Our Ref: R/238/14/PL

**Town & Country Planning Act 1990 (as amended)
Town and Country Planning (Development Management Procedure) (England) Order 2010 (as amended)
Application for Planning Permission**

Development 1No. dwelling & associated landscapes works. Resubmission of EP/58/14/PL
Location Land west of Paddock Place (Little Fosters) Tamarisk way Rustington

FIRST FLOOR
PROPOSED
1:100 @ A3
4112-6^A

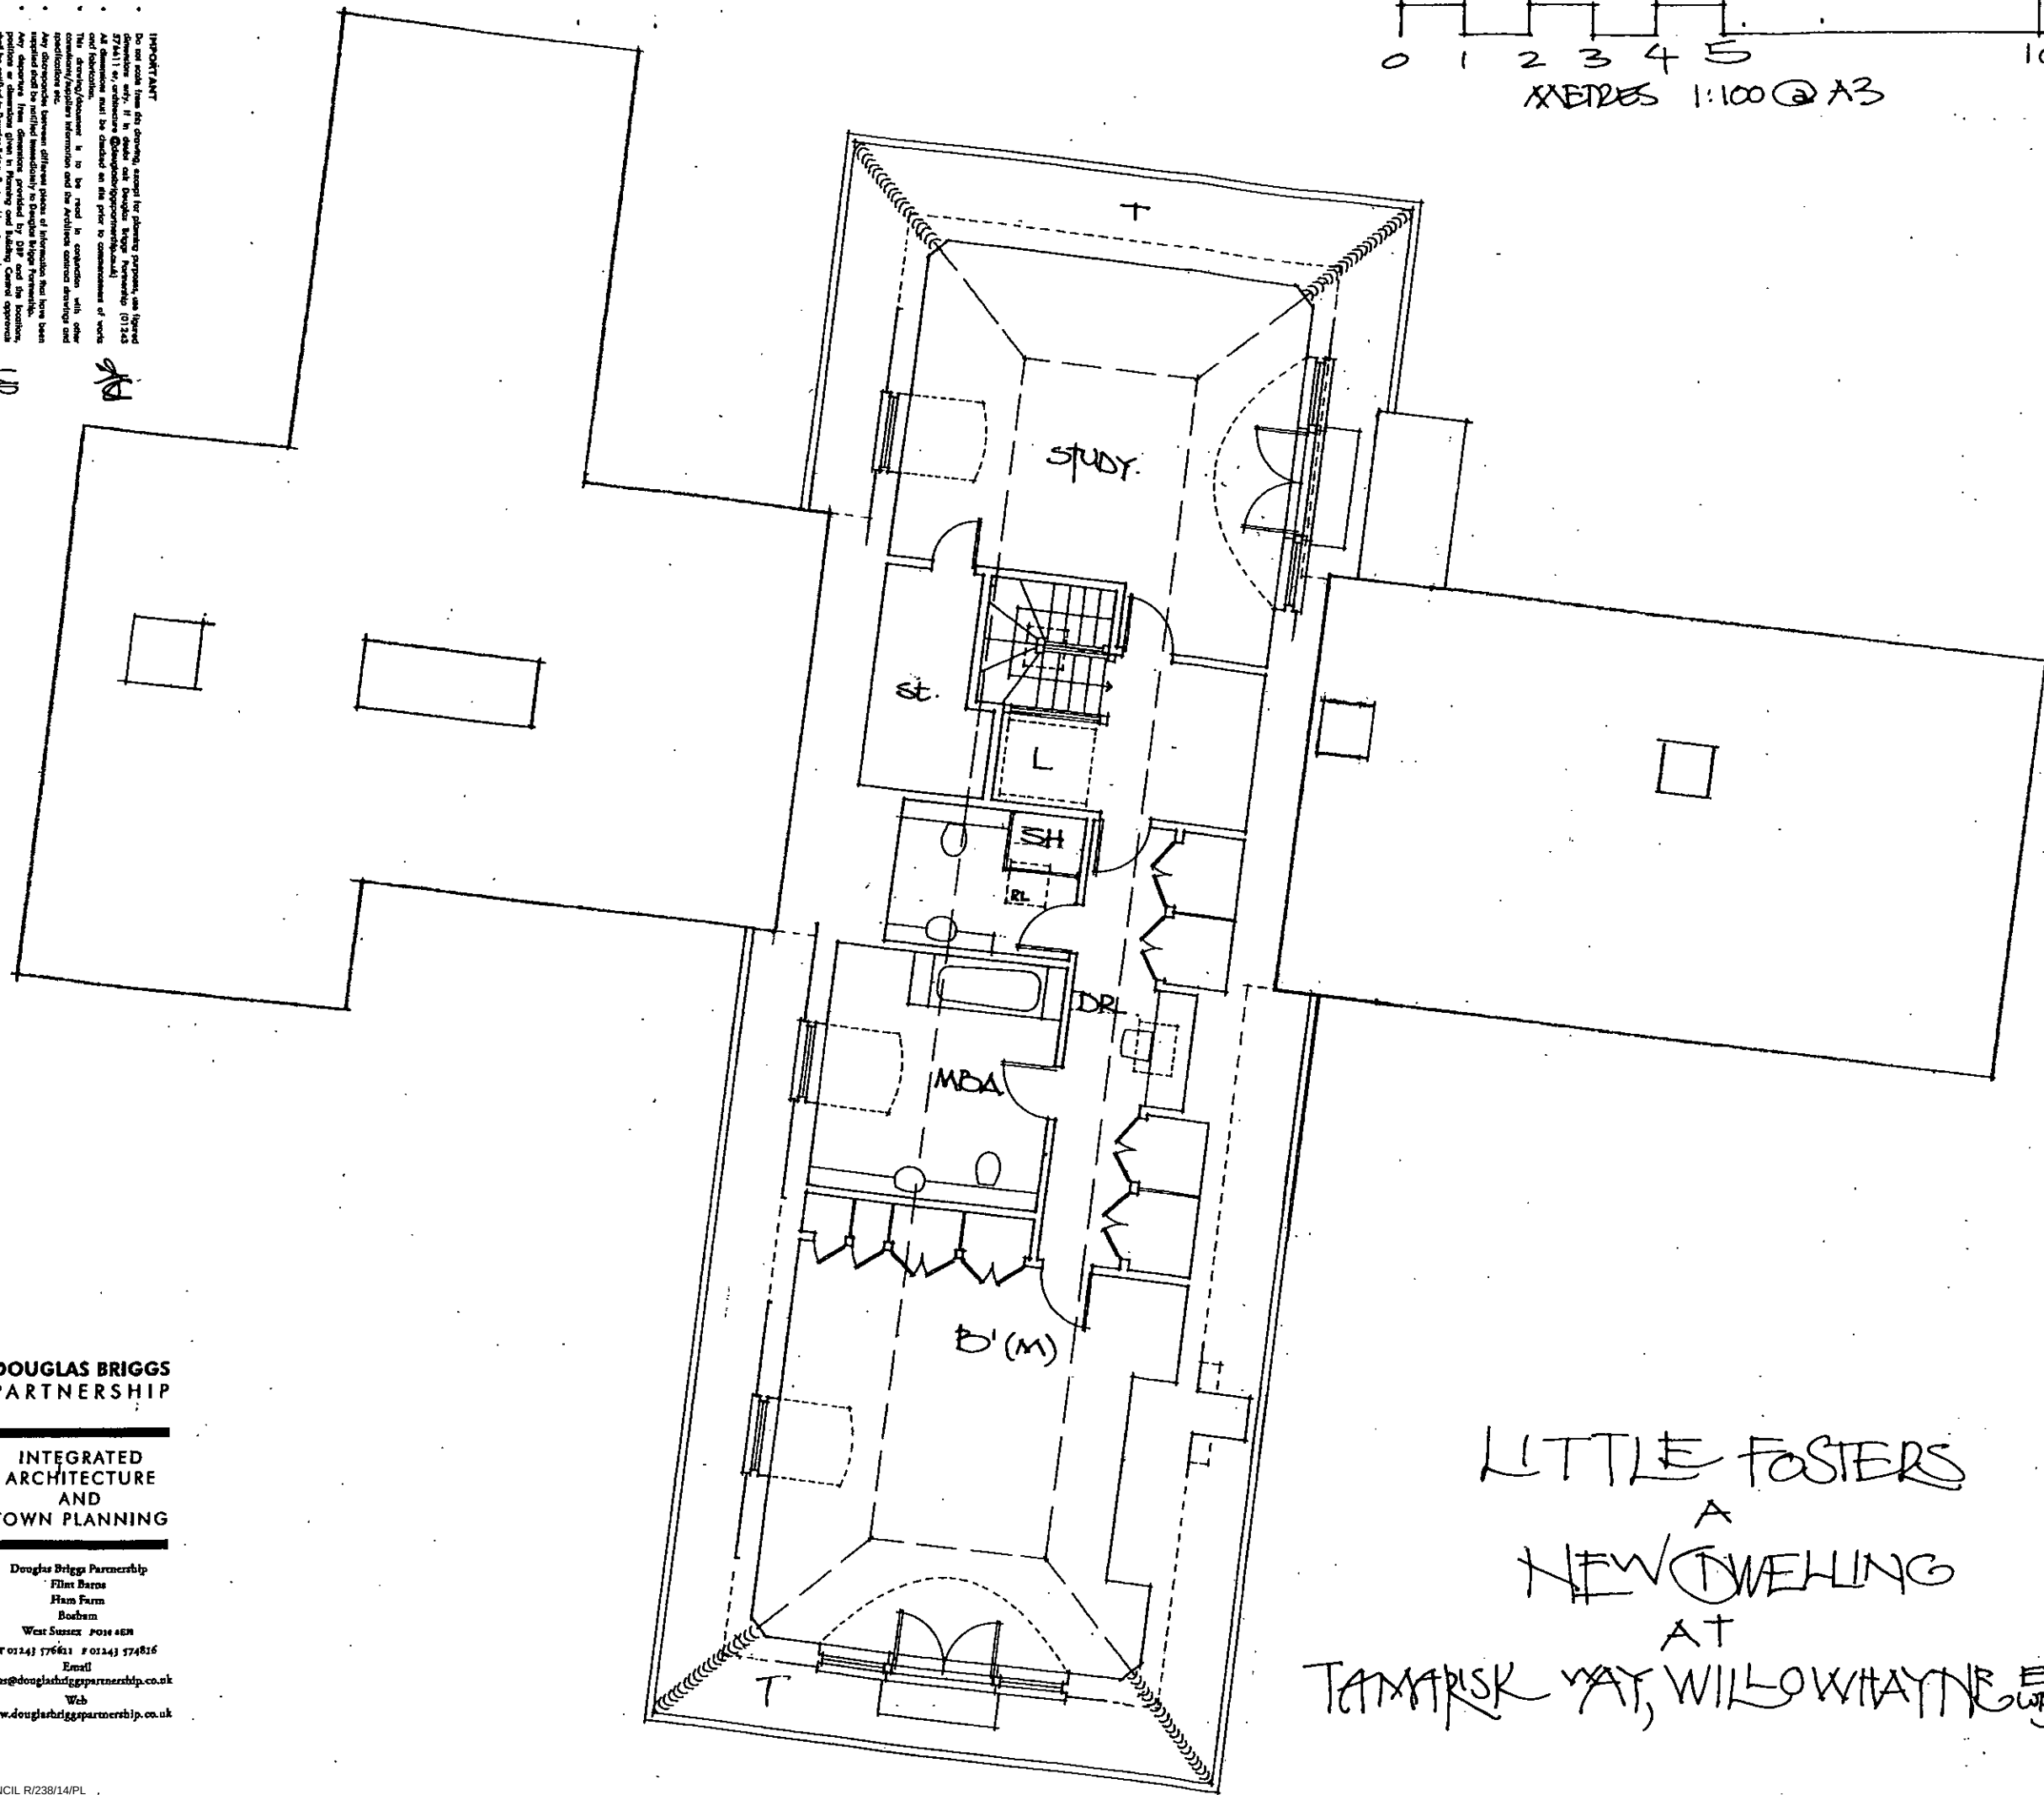
Please submit 1 electronic or 3 paper copies of clearly labelled revised proposed floor plans at a scale of 1:50 or 1:100. Further details can be found in the National Validation Requirements. You have indicated a window on the West elevation but not on the floor plan.
